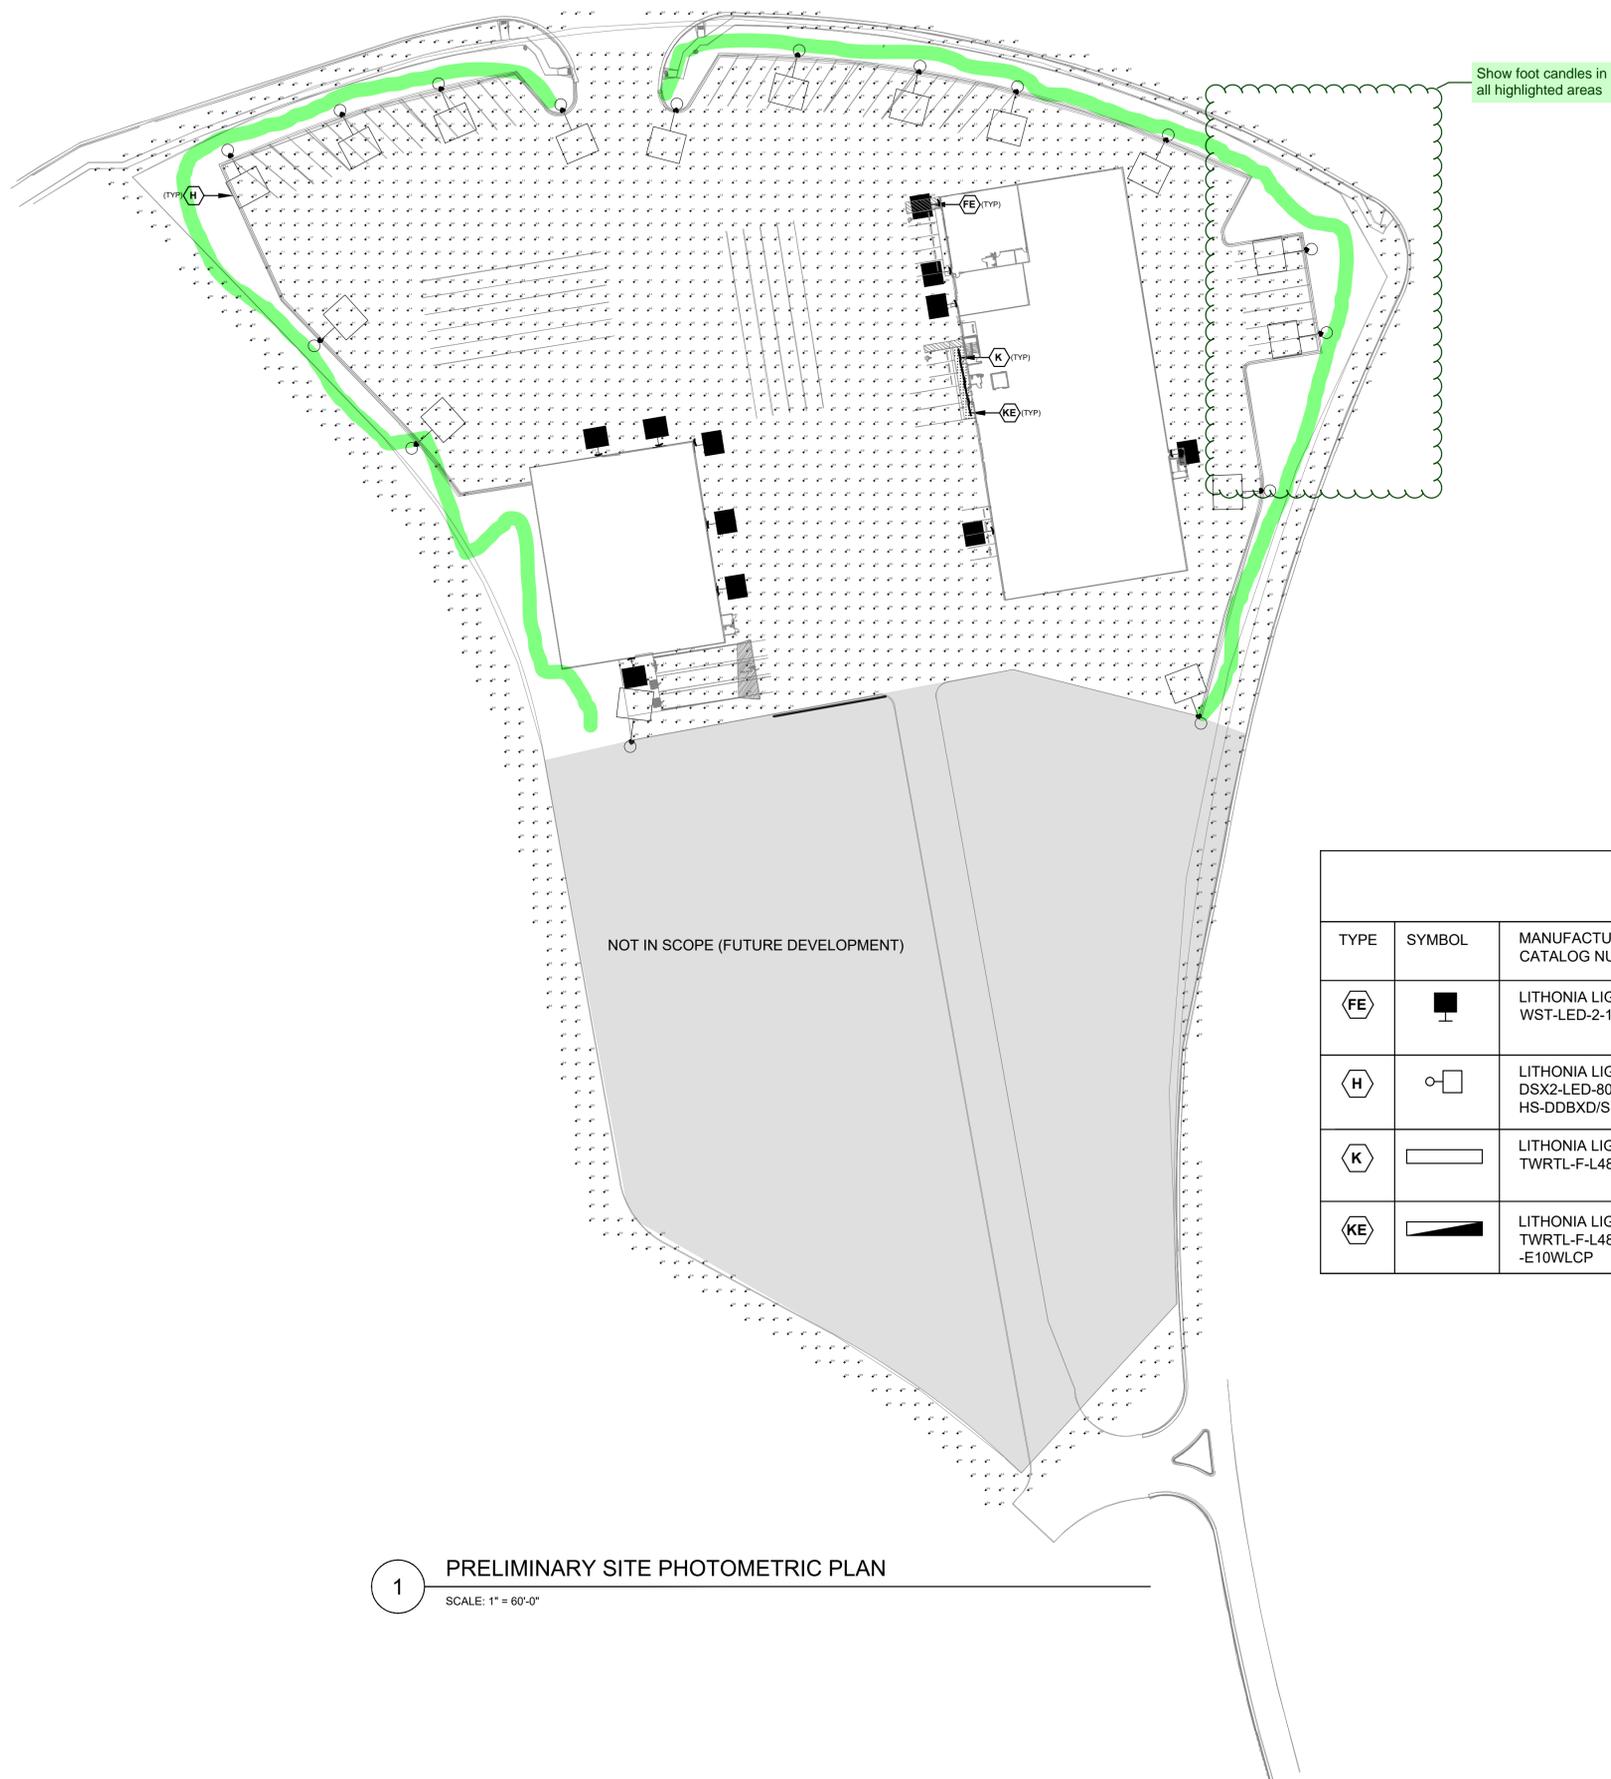
This plan needs to show full site photometrics - there are gaps where it is unclear how the lighting levels transition from the fixtures to 0 foot candles at the property boundaries.

Please fill in the southern portion of the site as well.

20 ft is only allowed for parking lot lighting - all other pole mounted fixtures have 15 ft max height.

RESPONSE: Comment noted. Photometric has been updated to show photometric data on the site in its entirety.

Changed fixture to lower lumen/wattage.

RESPONSE: Comment noted, 15FT maximum mounting height incorporated into photometric. Schedule updated.

Changed to type "TFTM" optics (forward throw) to reduce light bleed behind fixtures. Also added EGS (external glare shield) option.
